SANDIA COLLISION CENTER

DRB SITE PLAN COMMENTS & RESPONSES

PROJECT NUMBER: PR-2019-002821

HEARING DATE: June 9, 2021

SHEET DESCRIPTION:
SITE PLAN

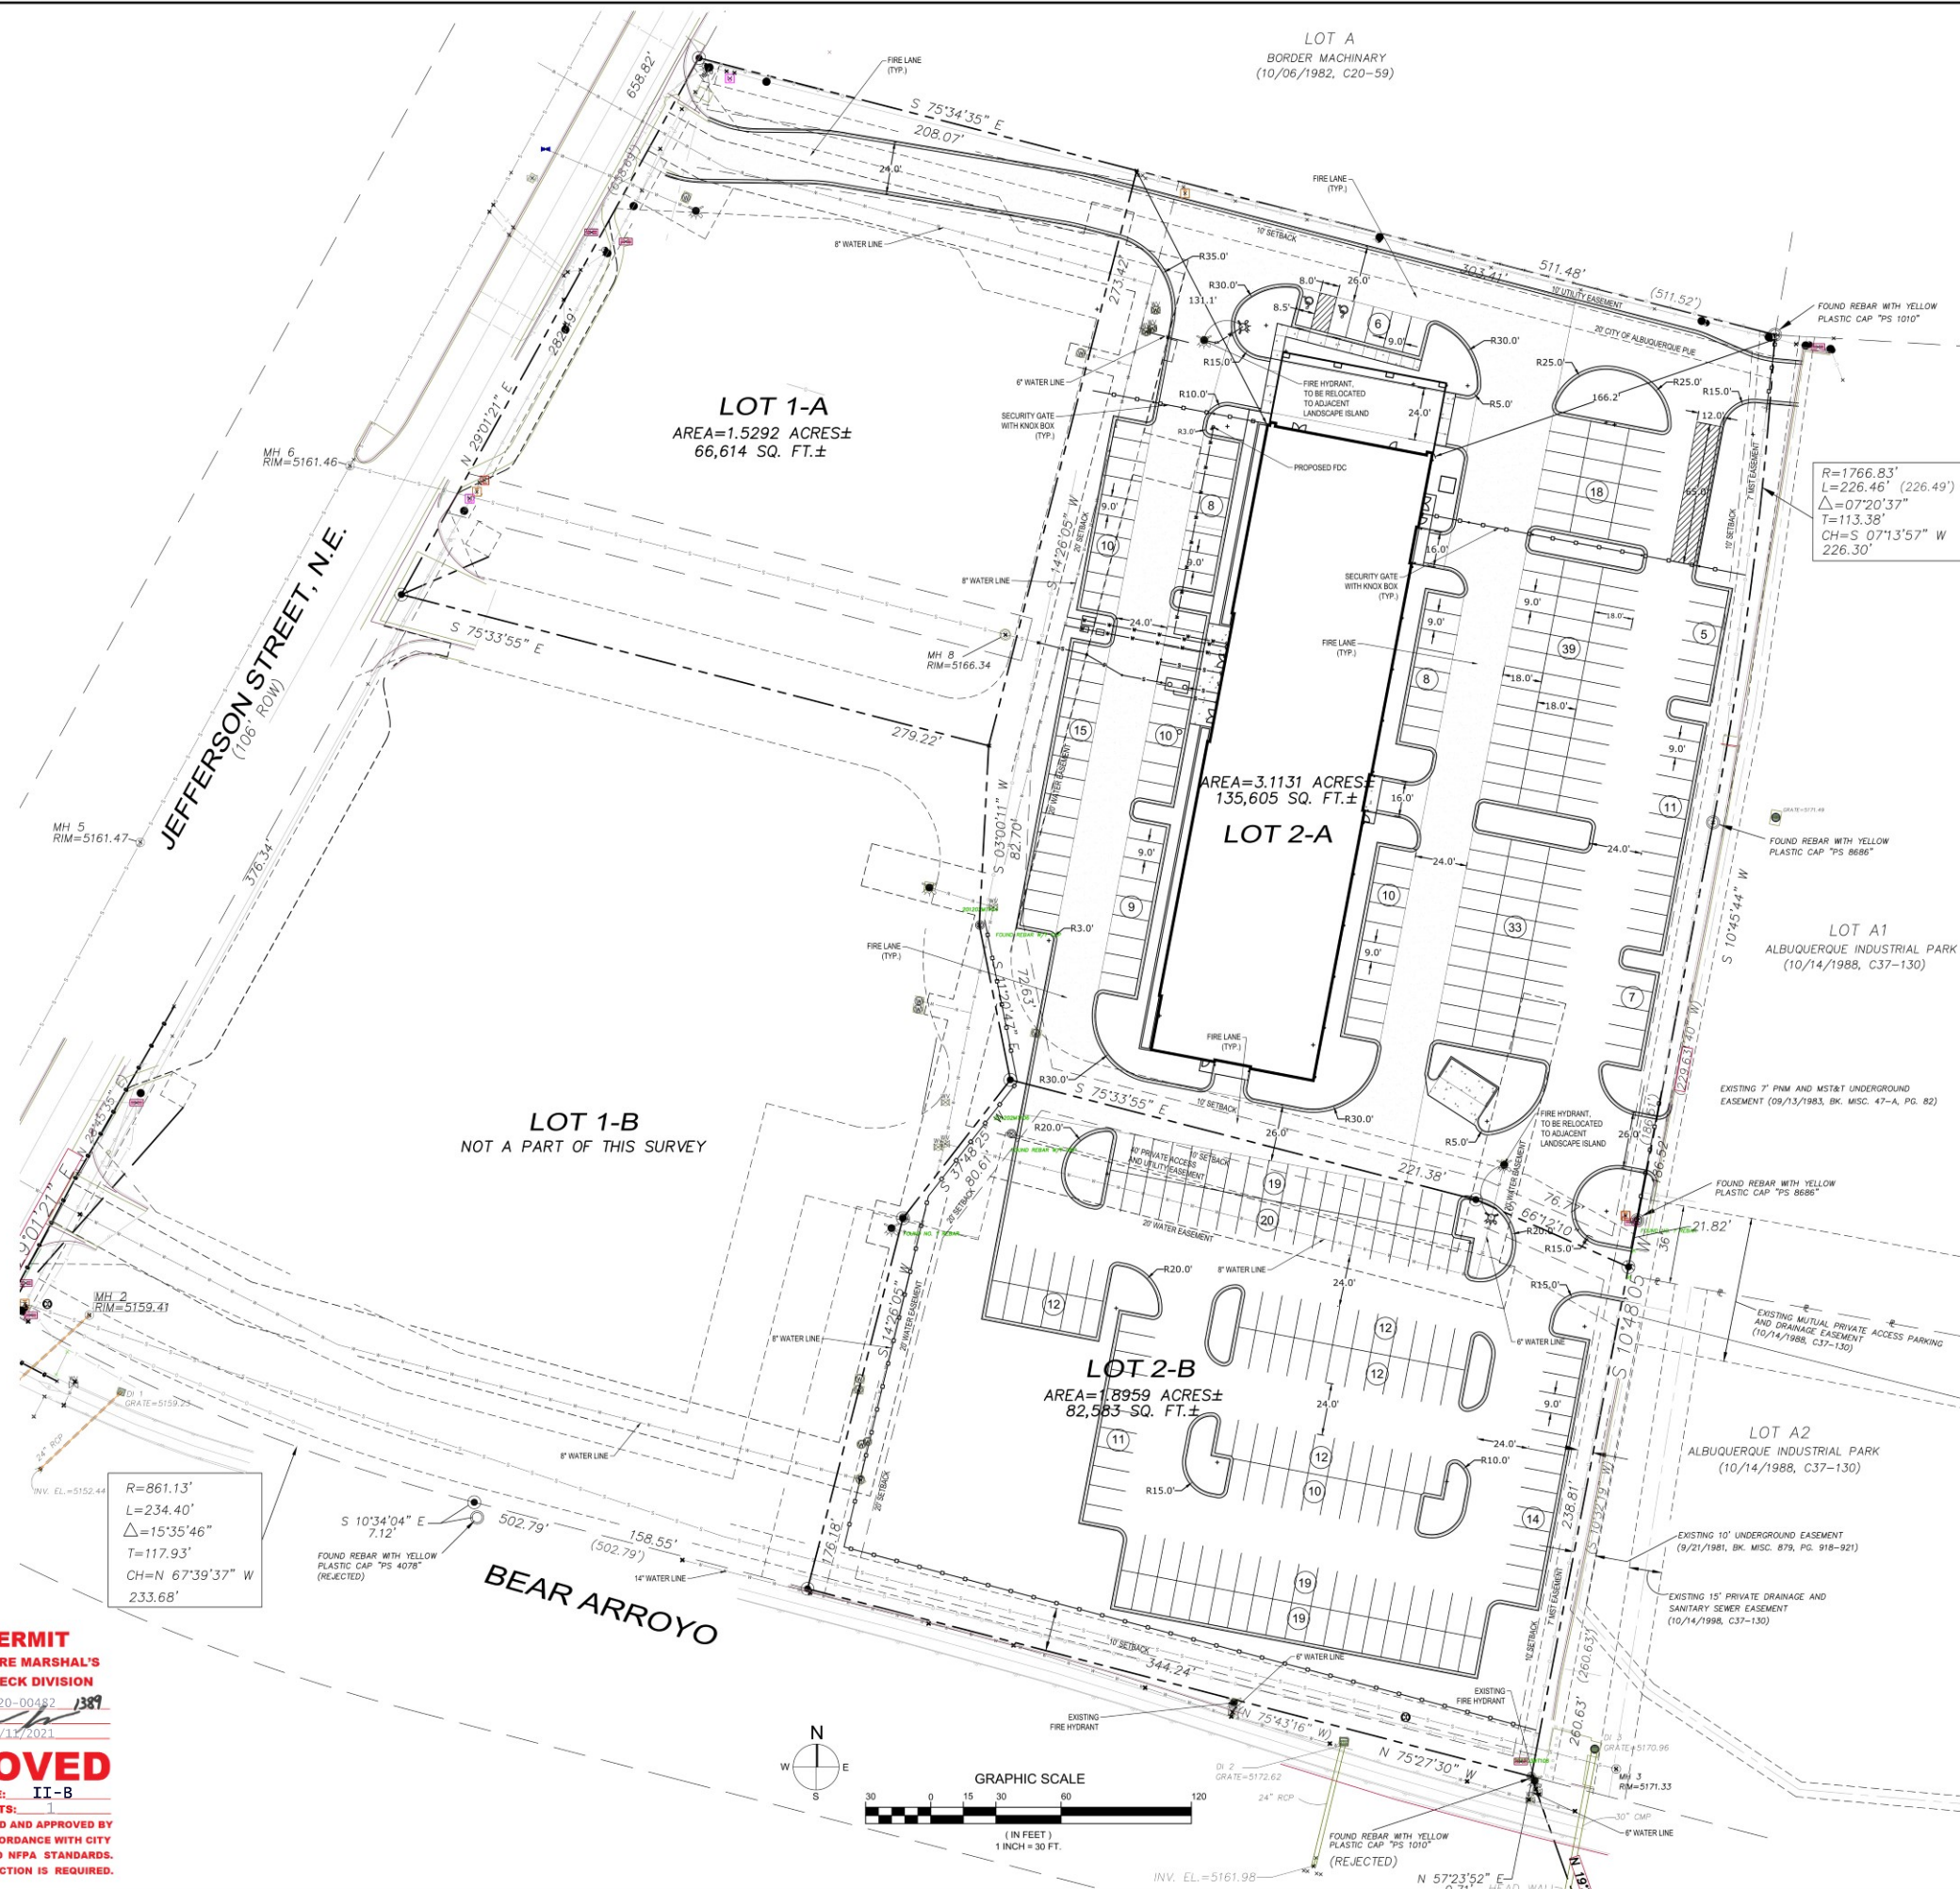
2. Clarify the parking calculations for the site-the Site Plan shows 260 spaces and says the 347 are provided. Is 347 the total for the whole development?

2. The existing hydrant to be relocated is a public hydrant. Additional easement shall be dedicated prior to its relocation. Could this hydrant be relocated to the west side of the drive aisle to better serve Lot 1-A in addition to Lot 2-A?

There are 346 striped parking stalls shown. Of these, 189 stalls are on lot2-a, and 158 are on lot2-B. We mistakenly counted the 2 motorcycle spaces as 1 parking space. We do not know where 260 spaces referenced in your comment are shown.

We will provide an easement for this hydrant. Fire-1 approval has been received in the current proposed location, but we do not see an issue moving it to the west side as suggested.
